Recommendation Report for Planning Permission for Works or Extension to a Dwelling

REF NO: WA/57/20/HH

LOCATION: 8 Prime Close
Walberton
BN18 0PL

PROPOSAL: Extension to roof and loft conversion

Project : Roof Extension
Title : Elevations
Drawing N.O : PL CC 0101 / 2020 REV A

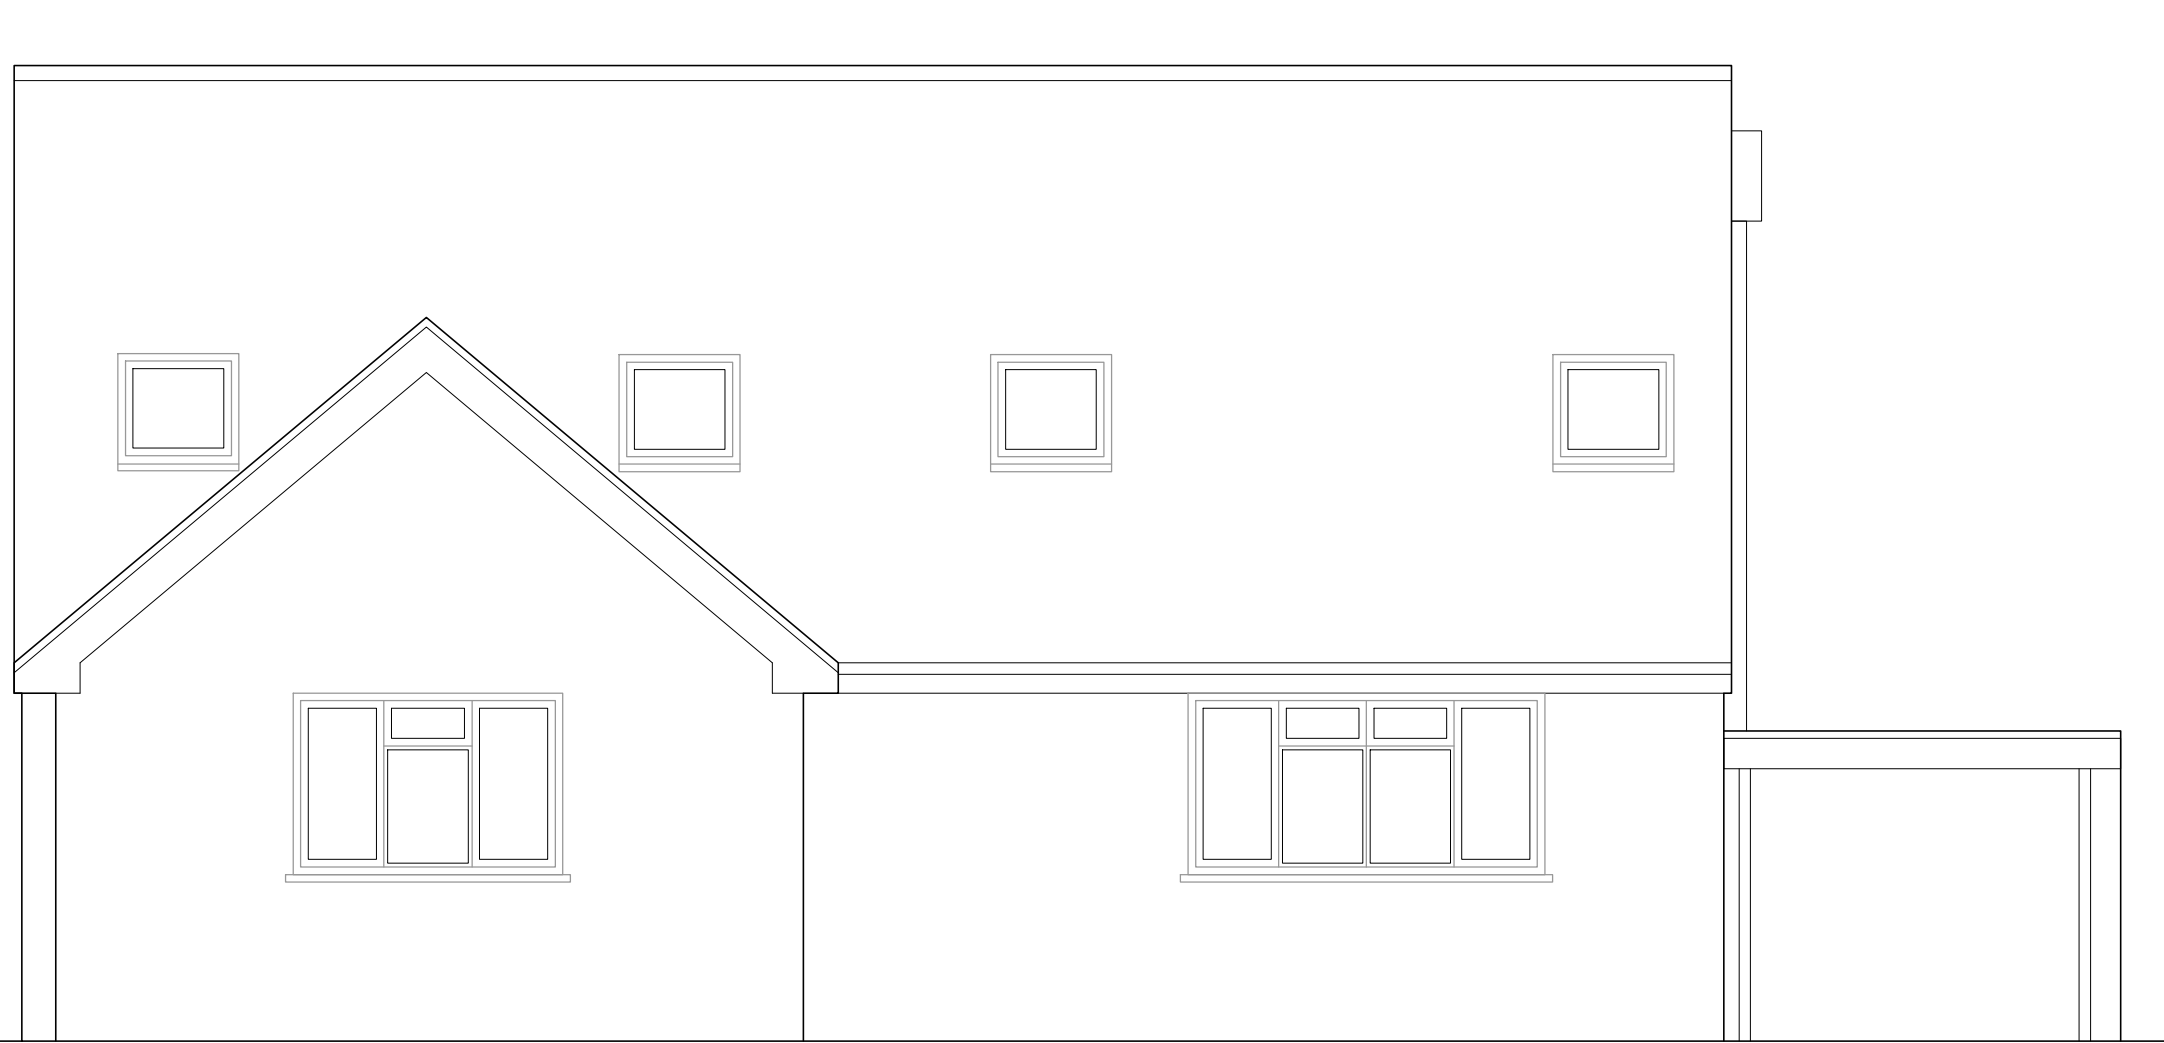
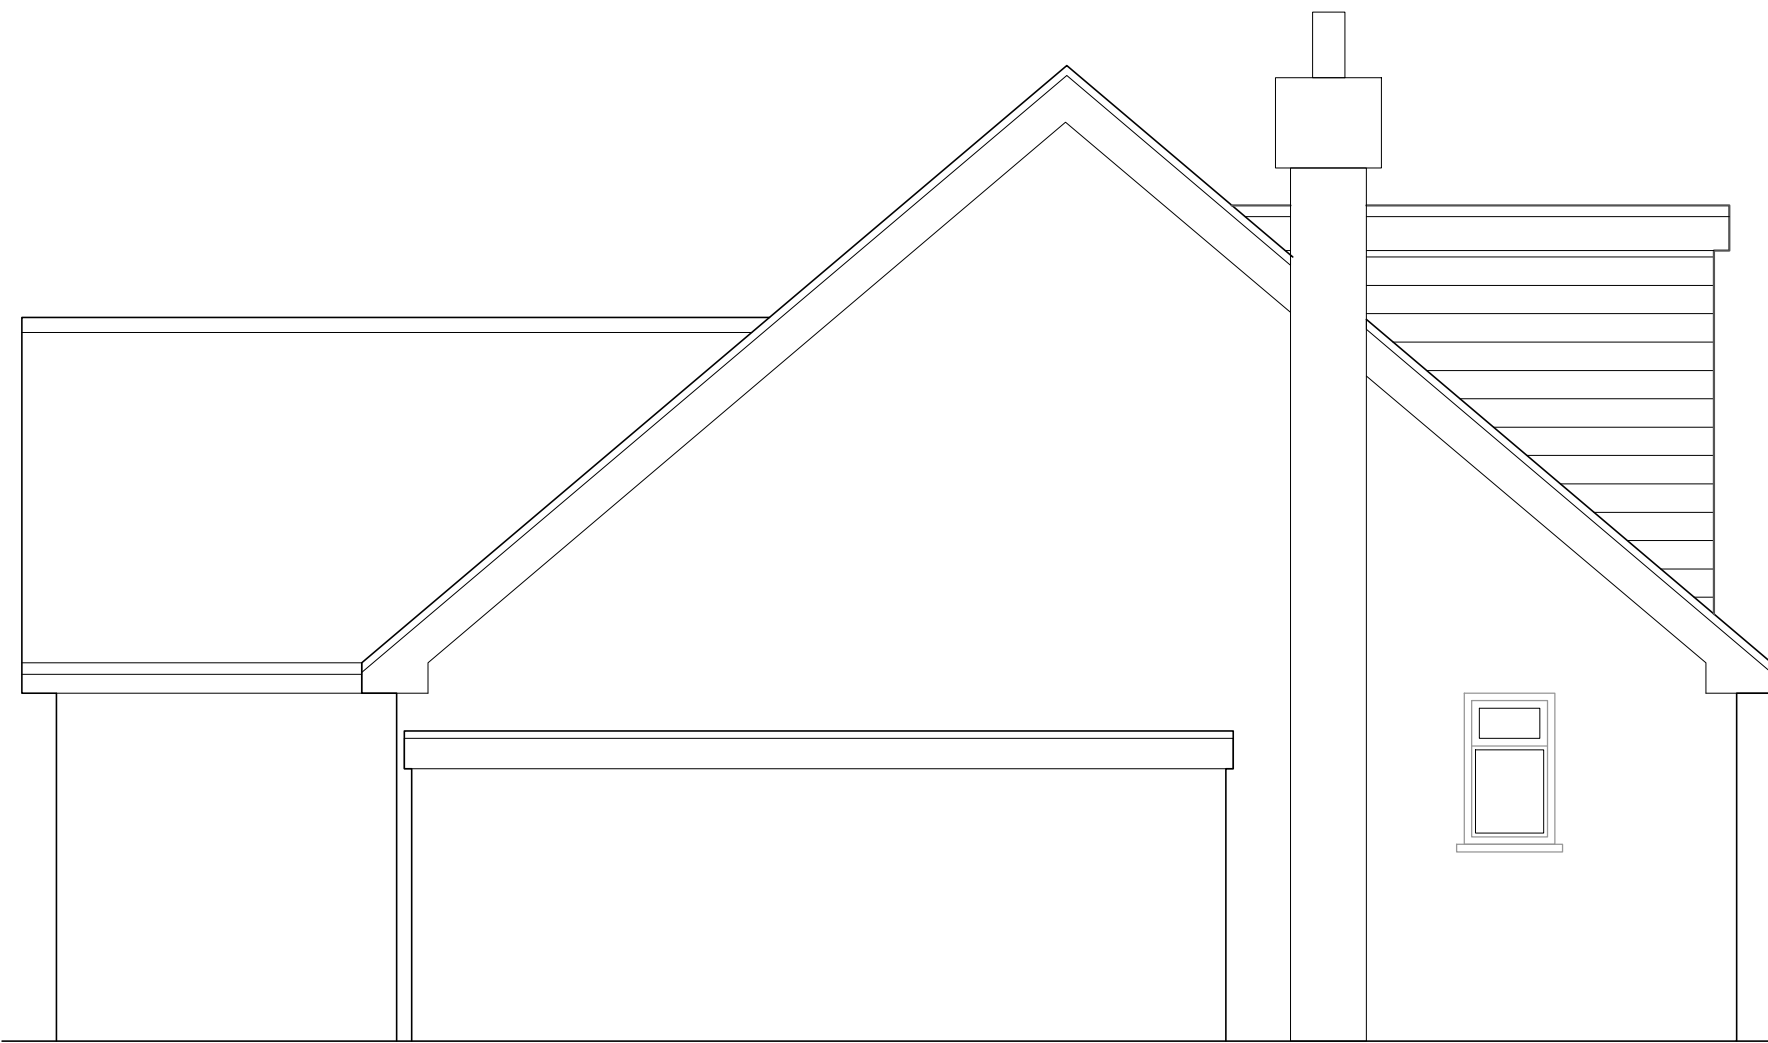
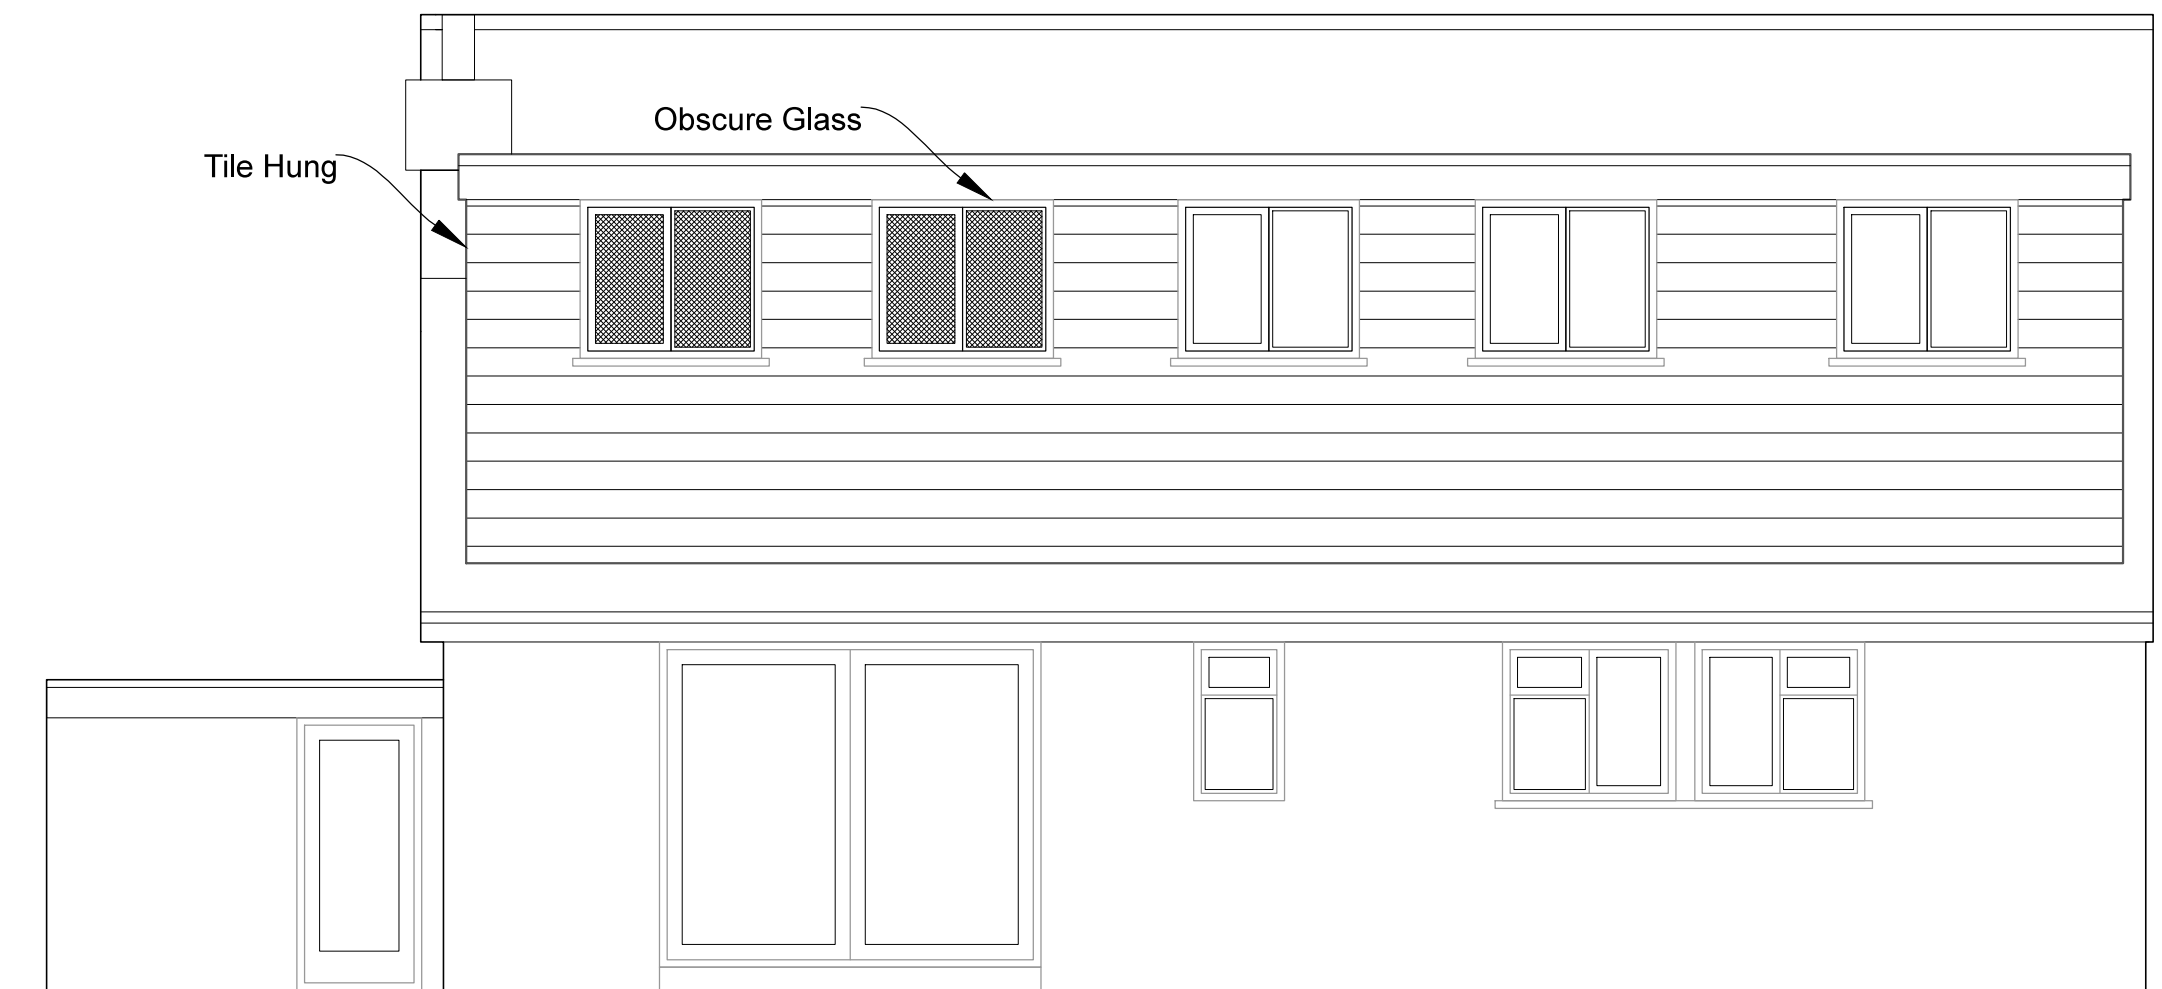
Due to the siting of the proposed dormer window, there will be few views of the proposal within the public view. As such, this element of the proposal is not considered to result in any significantly harmful impact upon the character of the locality, or that of the host dwelling. Furthermore, the scale of the proposed rear dormer is considered to allow it to appear subservient to, and well integrated with the host dwelling.

The proposal involves the insertion of rooflights into the front elevation of the host dwelling. This is considered to have no significant impact upon the character of the host dwelling, or its area due to its minor visual appearance and the fact that there are examples of similar windows within the area.

The proposed development is not considered to result in any significant overbearing or overshadowing impact upon the occupiers of nearby dwellings. This is due to the lack of increase in built form of the proposal, and the dormers separation distance from any affected windows or openings. Furthermore, with regard to potential loss of privacy to occupiers of neighbouring dwelling, it is not considered that the proposed openings would result in a significant loss of privacy to local occupiers. Whilst the modest separation distance between the rear dormer and the neighbouring garden to the East is noted, it is noted that similar views could be achieved through Permitted Development and it would therefore not be reasonable to condition that these windows be obscure glazed. The proposed rooflights are sited on the front roofslope of the host dwelling, and therefore provide views of the street scene only.

- Roof Extension - Floor Plan - PL CC 0102/2020 - Rev. A - 02/11/2020
- Roof Extension - Elevations - PL CC 01/01/2020 - Rev. A - 02/11/2020
